Attachment A – Detailed Response to Submissions Table

Attachment A – The Sutherland Hospital Operating Theatre Upgrade (SSD-11099584) – Detailed Response to Submissions Table

CLIENT	HDR
PROJECT	Sutherland Hospital Operating Theatres

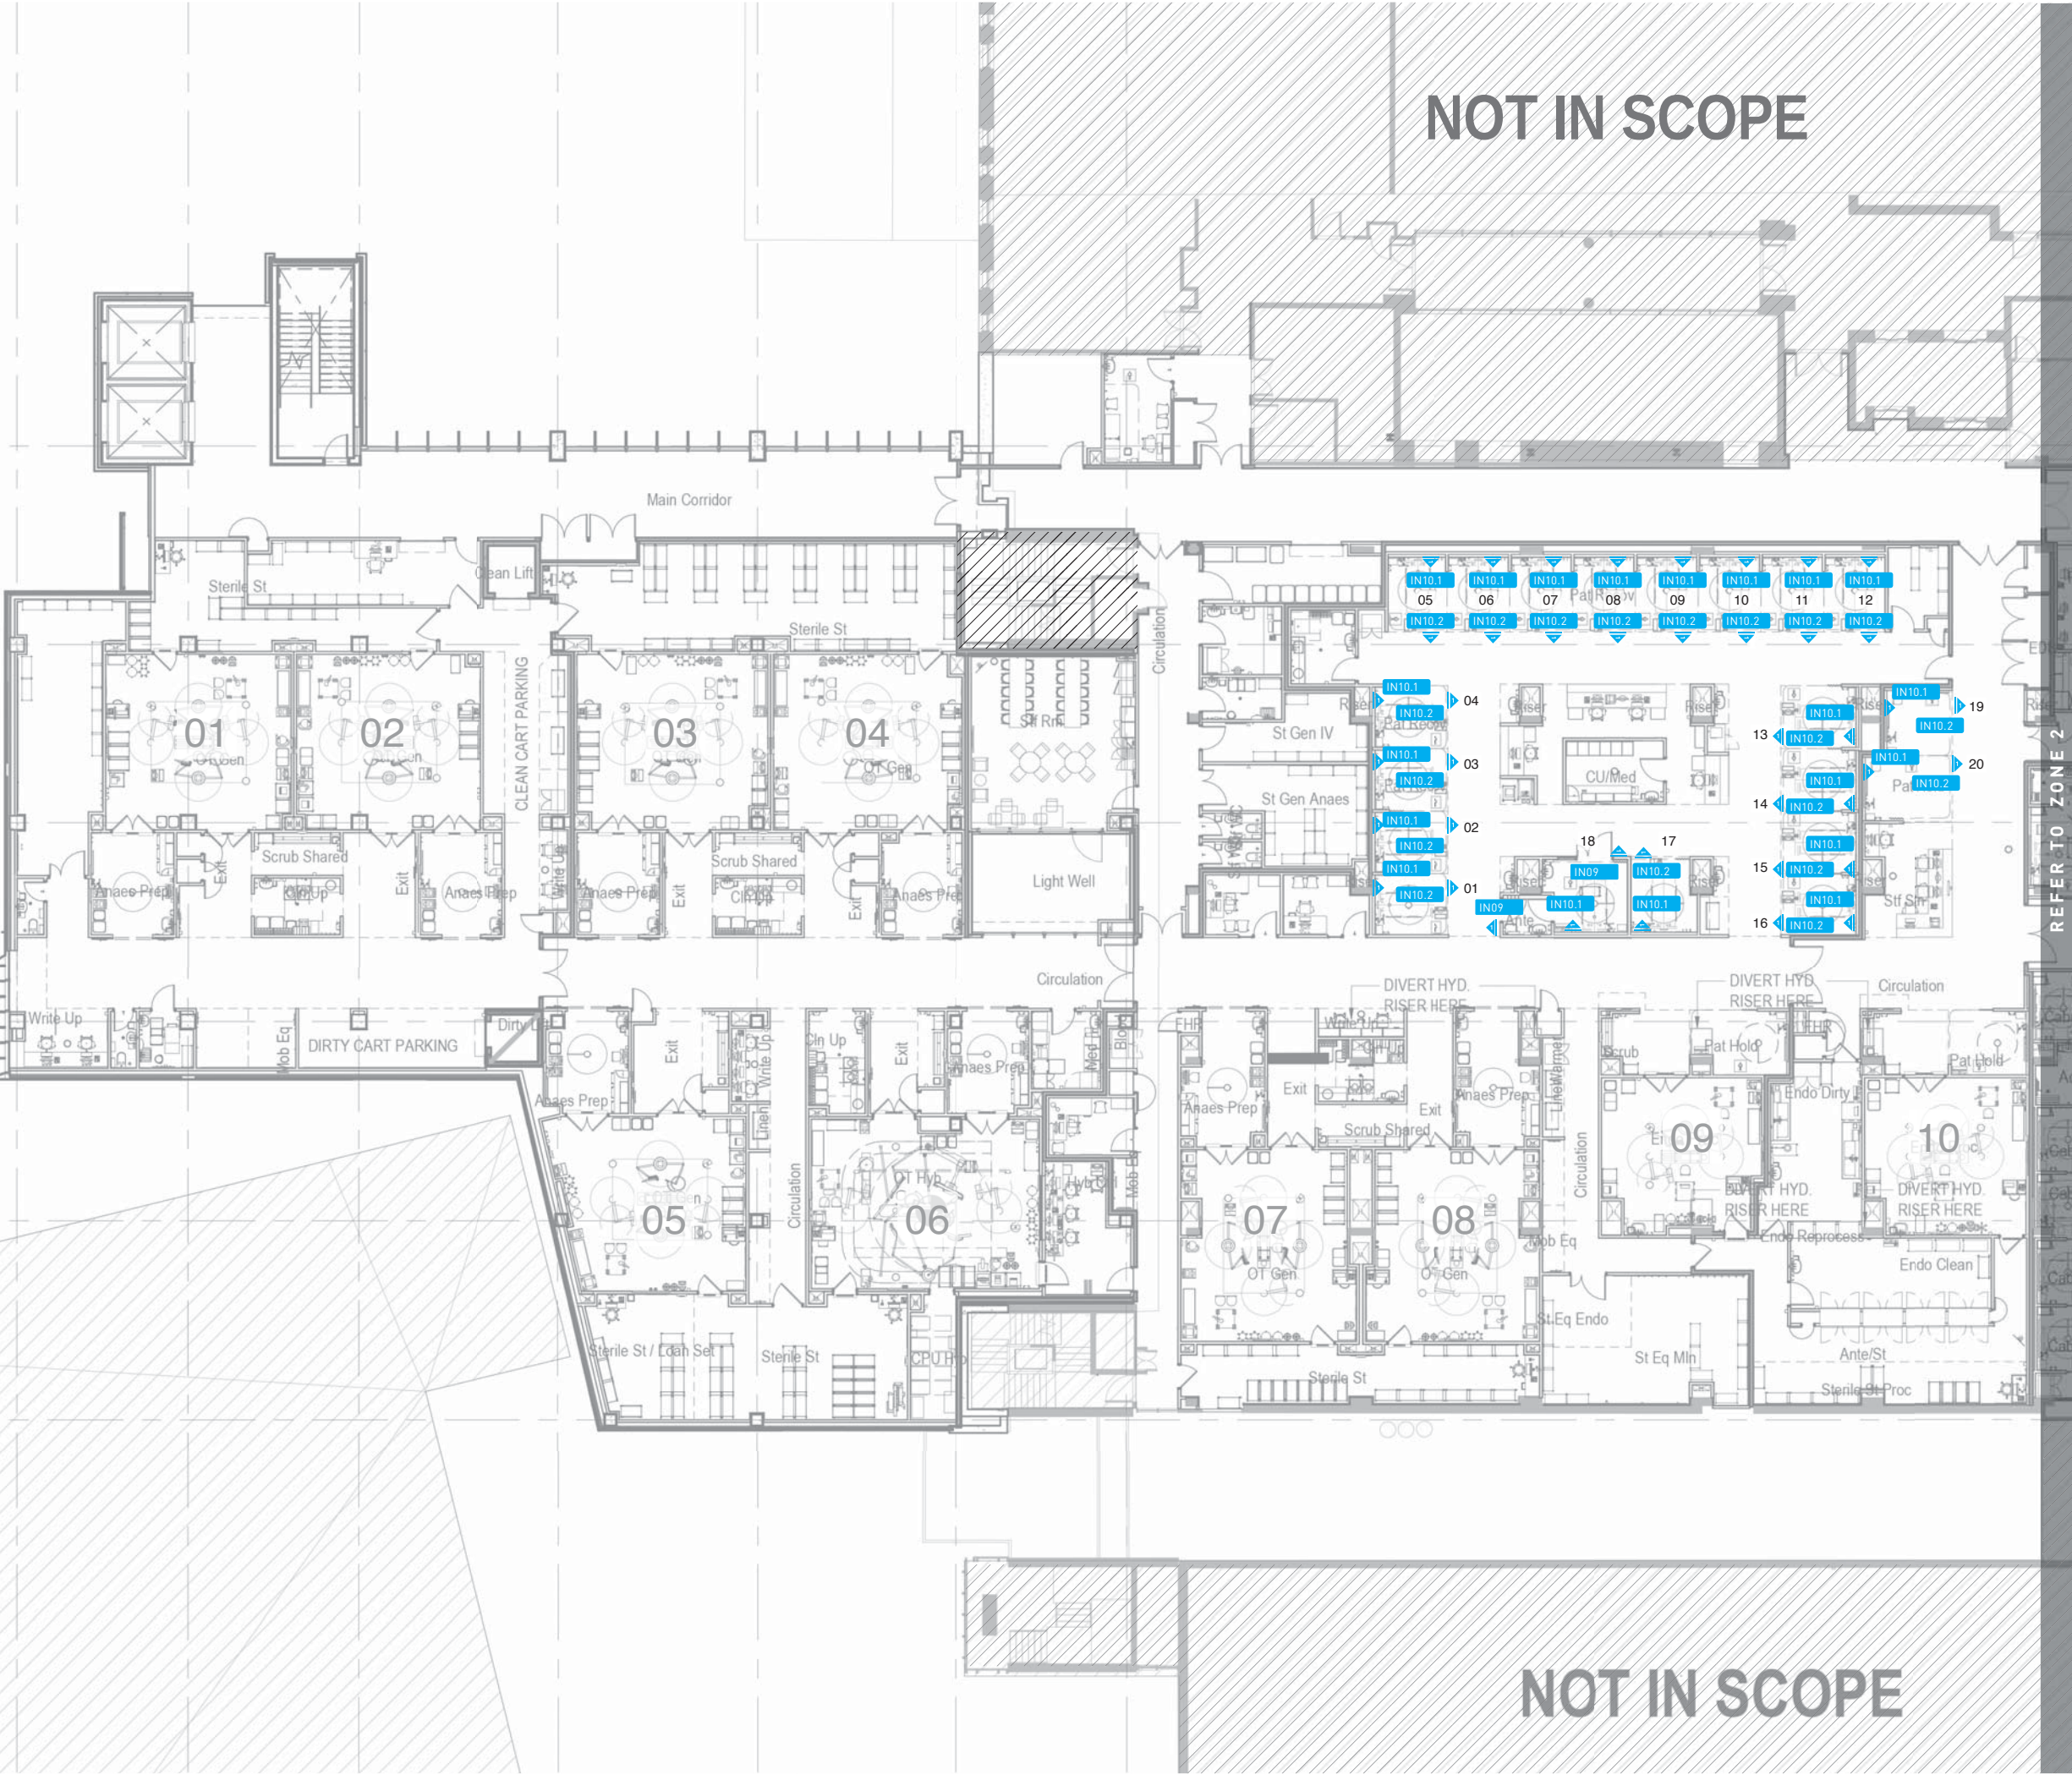
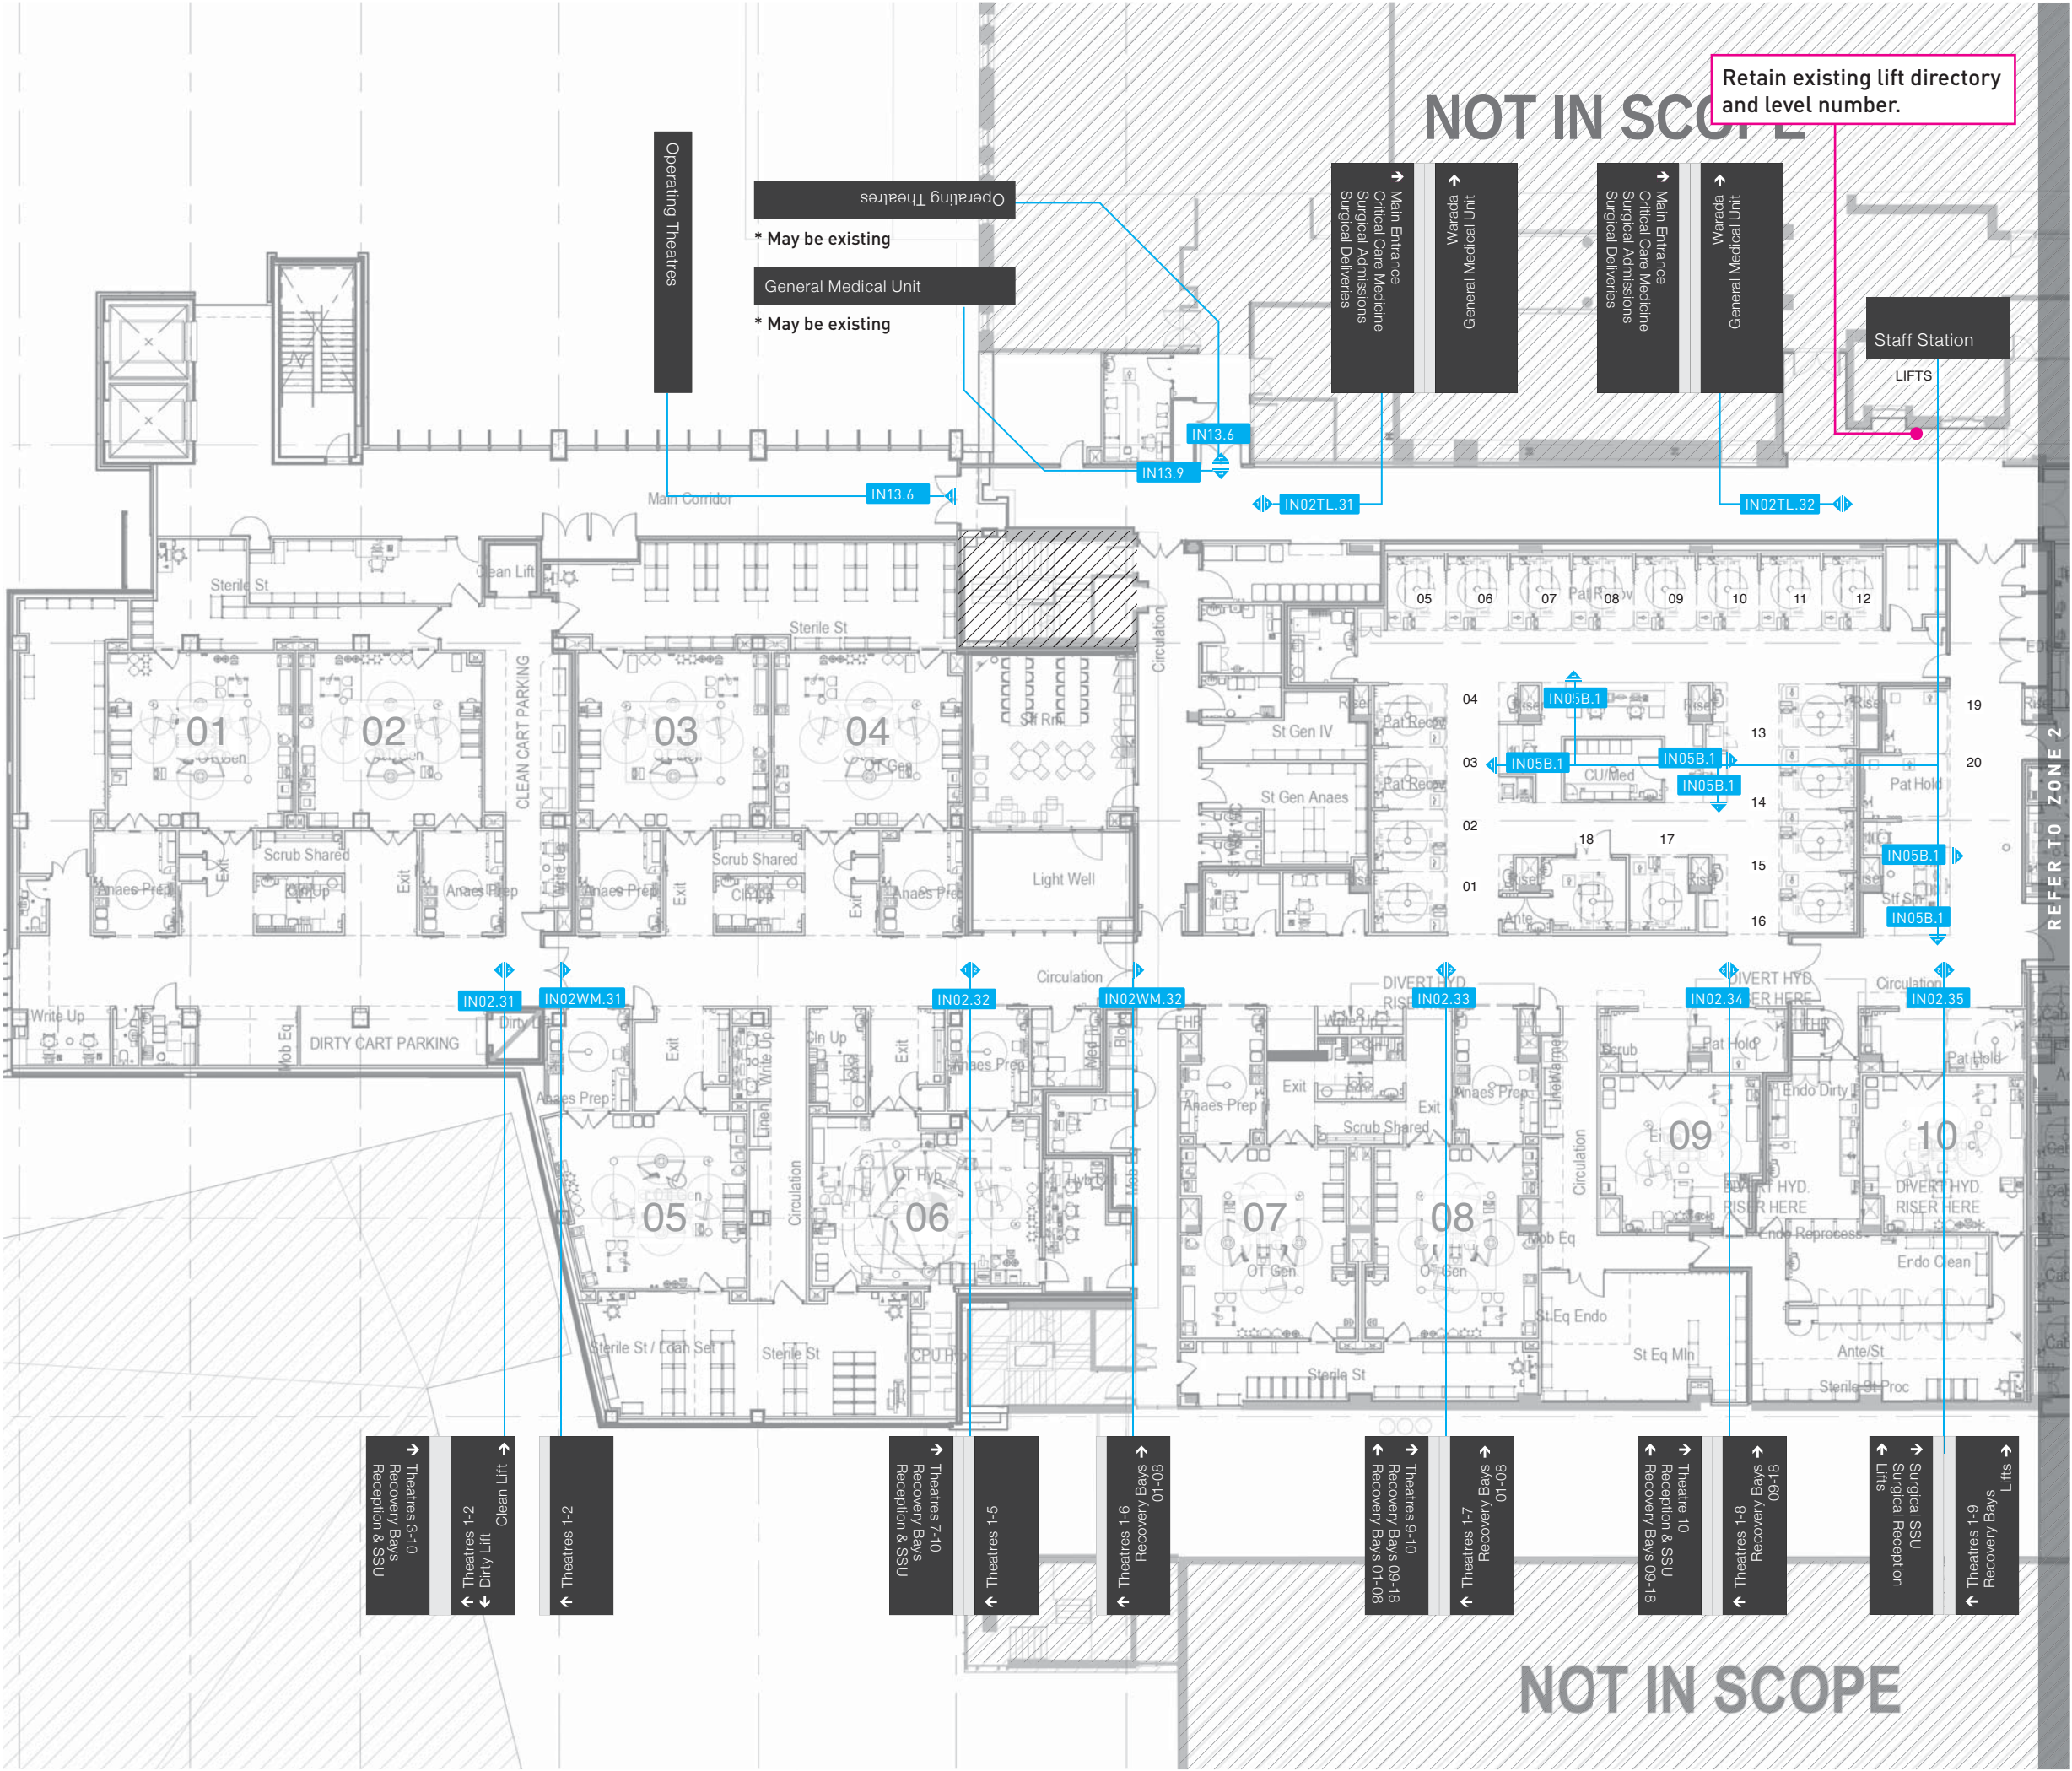
Issue raised in agency submission	Proponent's response
Department of Planning Industry and Environment (DPIE)	
<p>1 Access</p> <p><i>While the main hospital entrance is not being altered or changed in the proposal, the proposal also includes a smaller entrance, which may cause confusion when patients are entering the site. No signage has been included in this proposal but should be incorporated to improve wayfinding across the site.</i></p>	<p>A wayfinding strategy has been developed for the proposed development by Brandculture and is provided at Attachment C and Figure 1 below.</p> <p>The wayfinding strategy provides further information on the legibility of the entrance to the building including the signage to be used at the entrance fronting the car park. As depicted below the signage on this frontage is quite minimal so as to not appear as a key entrance to the public. Note also that the signage notes that Level 1 is for staff only.</p>  <p>Figure 1 Proposed wayfinding signage at the entrance to the operating theatre building. Source: Brandculture</p>
